Harnett County Government Complex
307 Cornelius Harnett Boulevard
Lillington, NC 27546

April 13, 2005

**Re: Status of Improvement Permit Application #05-5-11319R
Lot 79 Woodshire**

H&H Lot 79 Woodshire

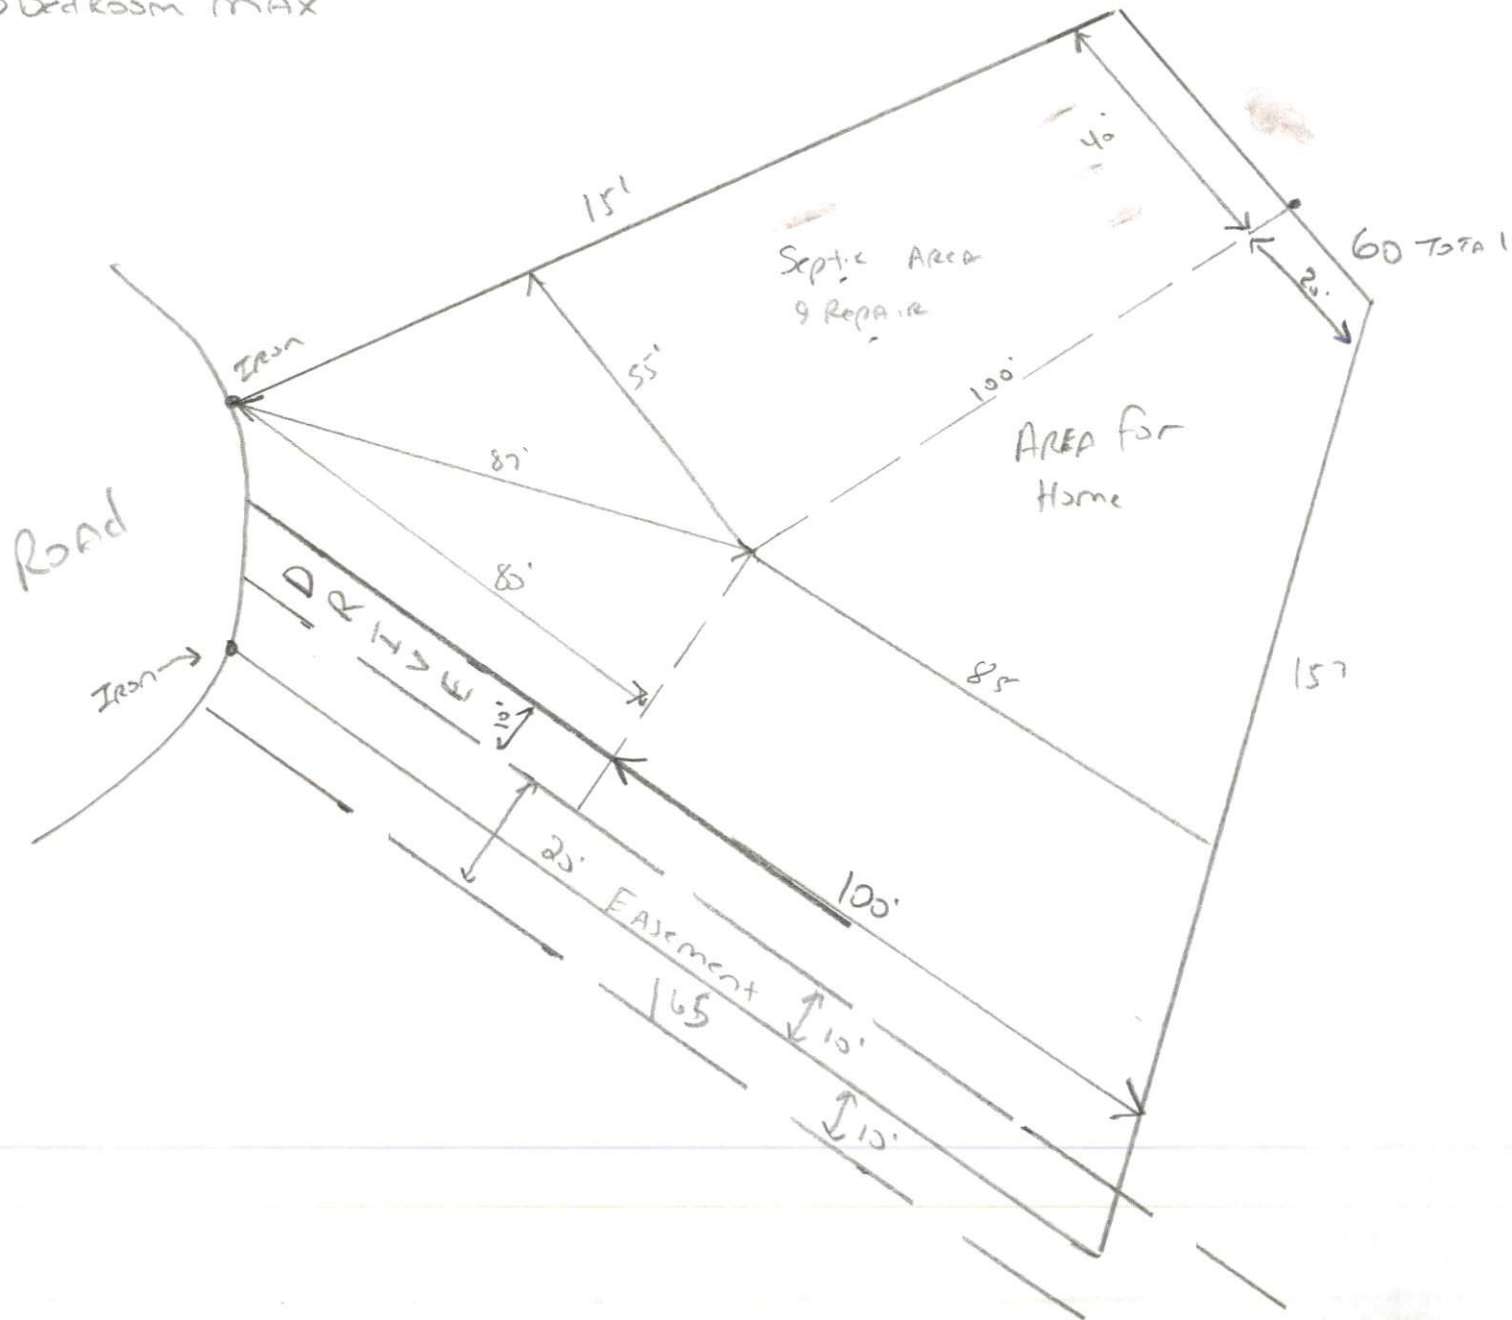
6. Other *Home must be 3 bedrooms and moved within area I have flagged. (see enclosed map)*
NOTE: Drive must be along property line with easement (10 feet) with drive being maximum of 10 feet wide until passing through septic area.
